Our Case Number: ABP-317809-23

Re: Proposed Coolglass windfarm and related works

Proposed Coolglass Windfarm and related works

I, Sile O' Connor, write in connection with the above listed planning application. As a local resident with knowledge of the location, I wish to object to the proposed development by Statkraft. Listed below are some of my summarised observations and concerns.

Figure 7-3 Laois CDP Map 3.2 – Wind Energy (Site superimposed)

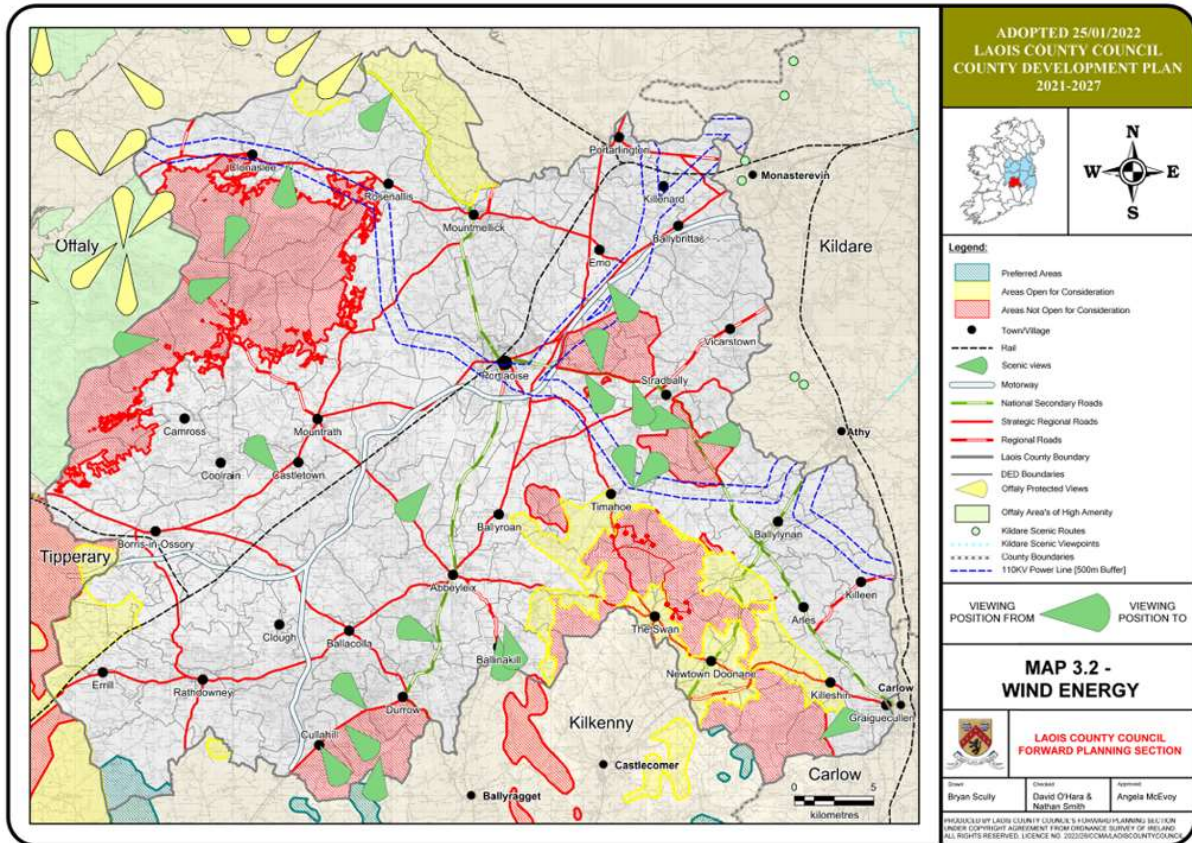
The location for the proposed development is in an area not open for consideration by the Laois County Development Plan and deemed unsuitable for wind development due to the sensitive environment. The proposed development sits in a Water Source Protection Zone (see CDP map 10.4). The Swan public water scheme identified by the EPA as being 'vulnerable and without an alternative source' is fed by the entire area of the proposed Wolfhill cluster. Water courses and streams which originate throughout the catchment of the proposed windfarm development, ultimately feed the River Nore and River Barrow, which are both noted for its sensitive stocks of fresh water pearl mussels and crayfish. The Bord needs to have regard in particular to the cumulative effect with regard to Margaritifera Margaritifera, dwrovcmsis, which requires protection under Directive 92/43/EEC, on the Conservation of Natural Habitats and of Wild Flora and Fauna.
